Section 55 Acceptance of Applications

A14 Cambridge to Huntingdon – Section 55 Application Checklist¹

**BUCKDEN ROAD NORTH WORK NO. 9 - WORKS PLANS SHEET NO. 7 (GENERAL ARRANGEMENT SHEET NO. 5 & 6)**

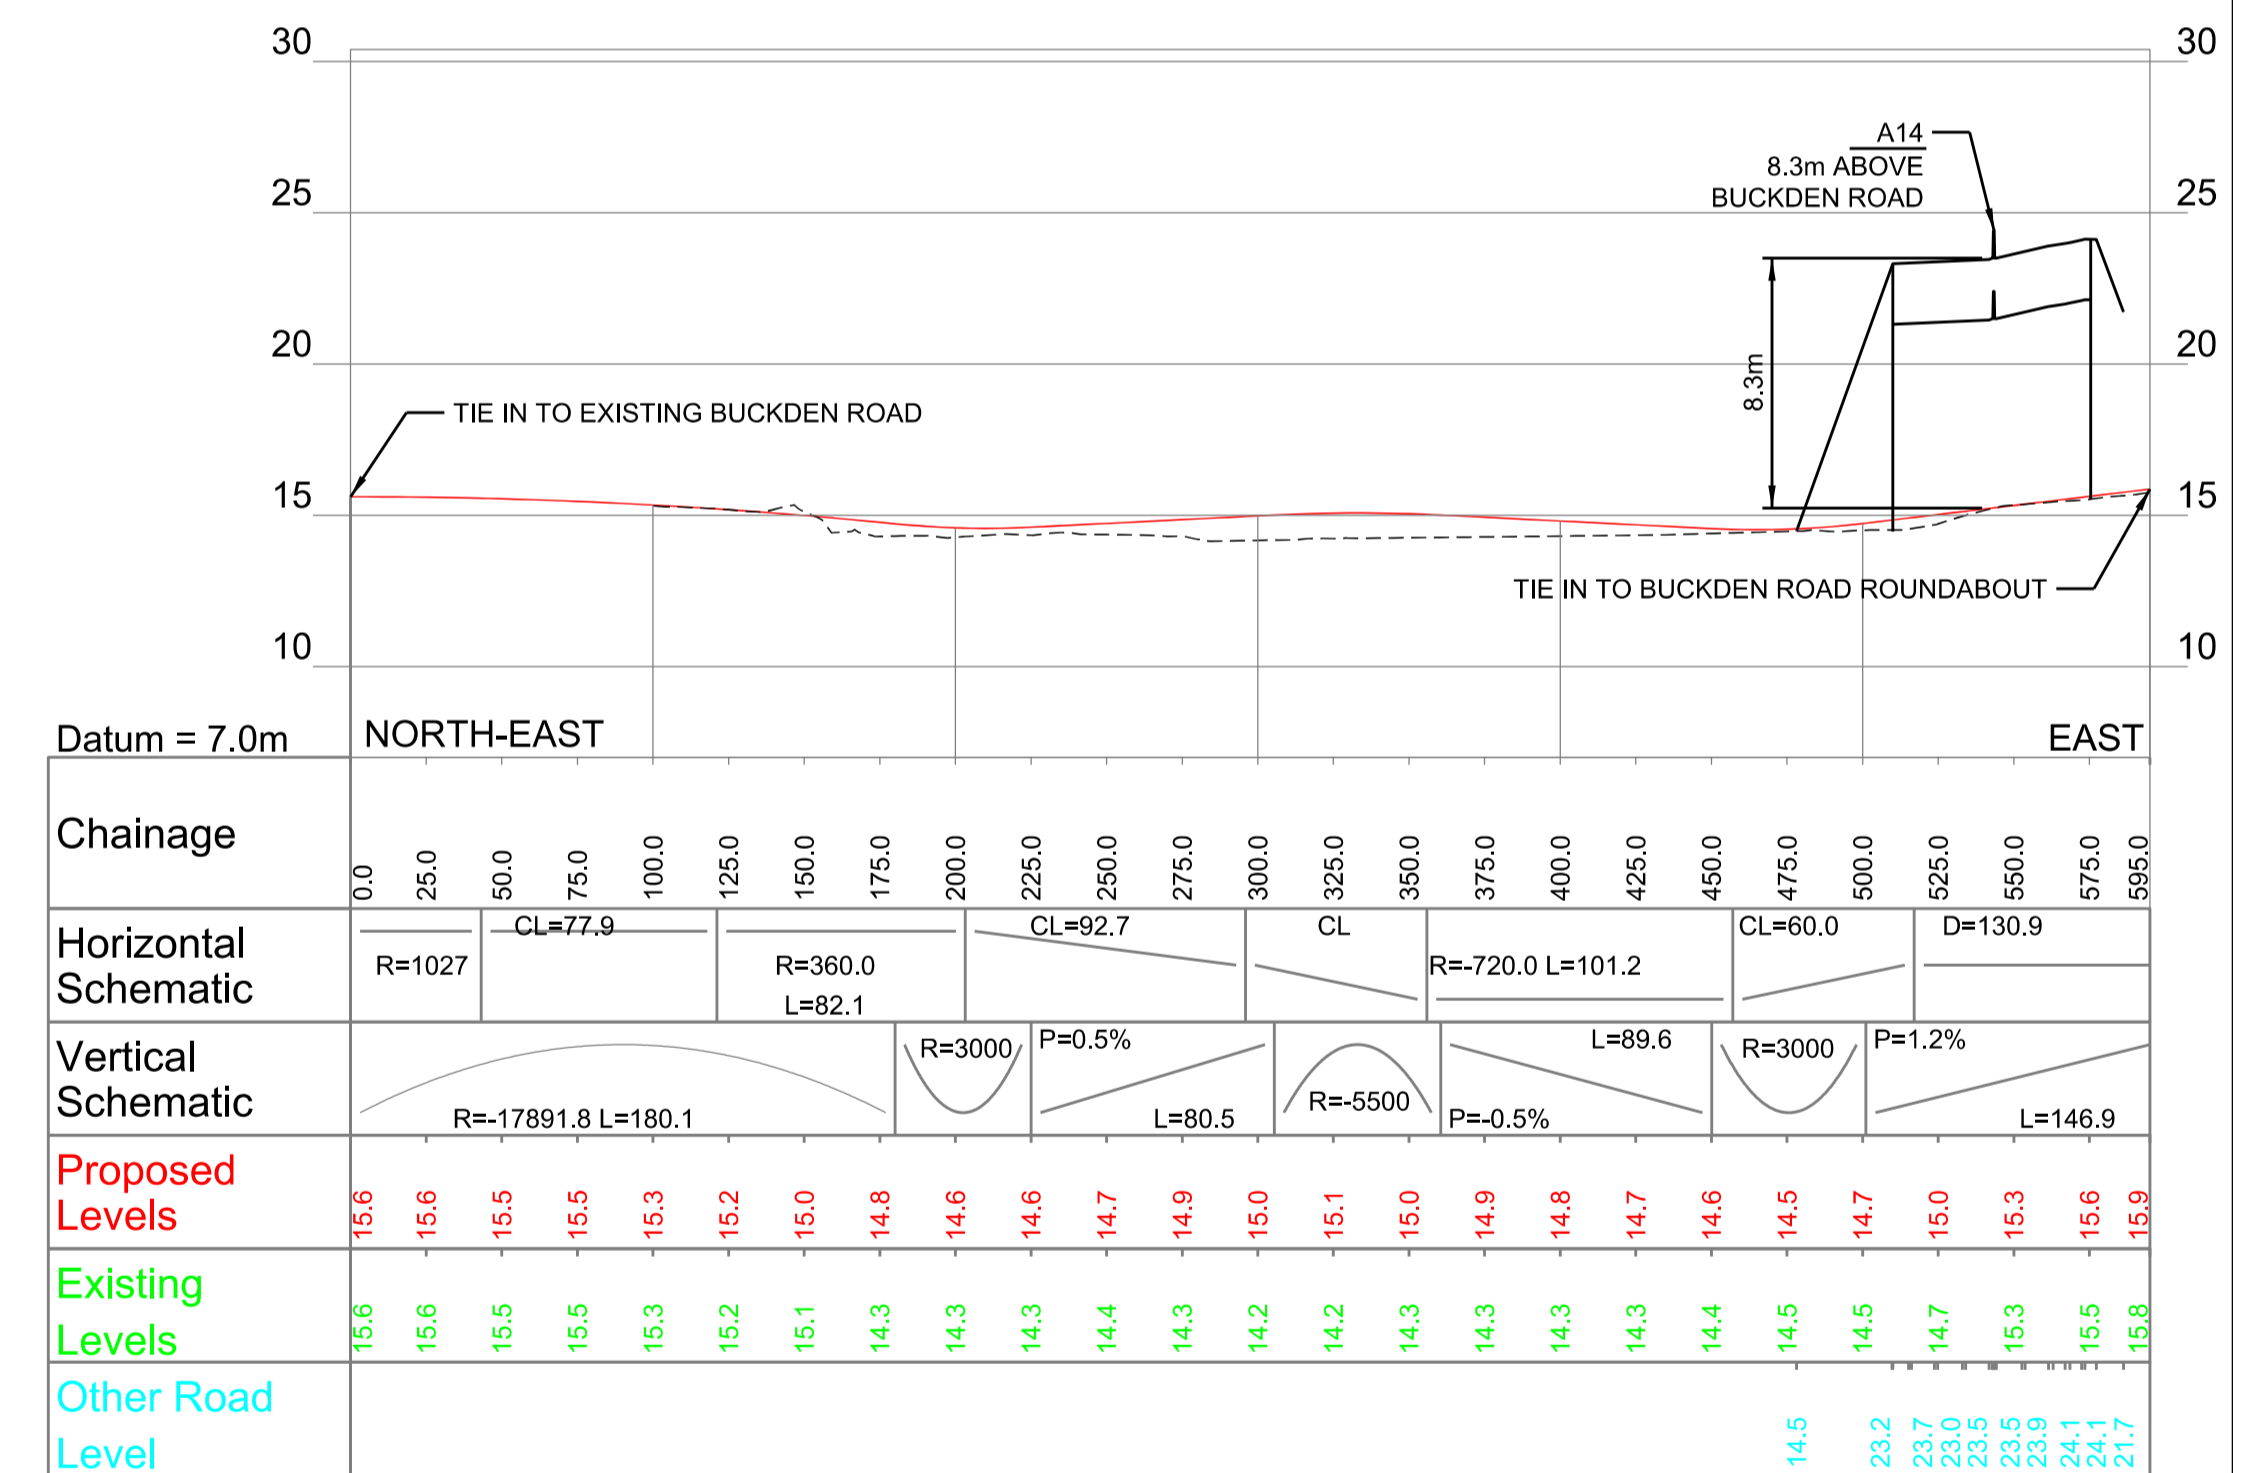
These drawings are generally to a lower standard. The heights of proposed bridges and embankments must be scaled; more detailed elevations would be preferable.

Most of the publically accessible carriageways are provided in section, though some accommodation roads and approaches to minor roundabouts have been omitted contrary to part (b).

There are a number of labelling errors which present a barrier to comprehension:

- A14 Mainline (sheet 3) – transverse A1 labelled as A14
- A1 to A14 Westbound interchange link (sheet 9) – transverse A1 labelled as A14
- A14 Eastbound Maintenance Offslip (sheet 11) – onslip labelled as offslip
- A1198 Ermine Street North Roundabout Link (sheet 12) – should state that it links north and south roundabouts
- Westbound Diverge Slip Road (sheet 14) – Emergency maintenance access labelled as diverge slip road
- Bar Hill Junction Services Access (sheet 22) – northwestbound merge labelled as northeastbound merge
- A14 westbound link (sheet 33) – westbound labelled as eastbound

Section drawings should be arranged logically and each drawing should be labelled with cardinal points. Minor roads in Huntingdon centre should be much more clearly differentiated. Further advice on this is issued separately.
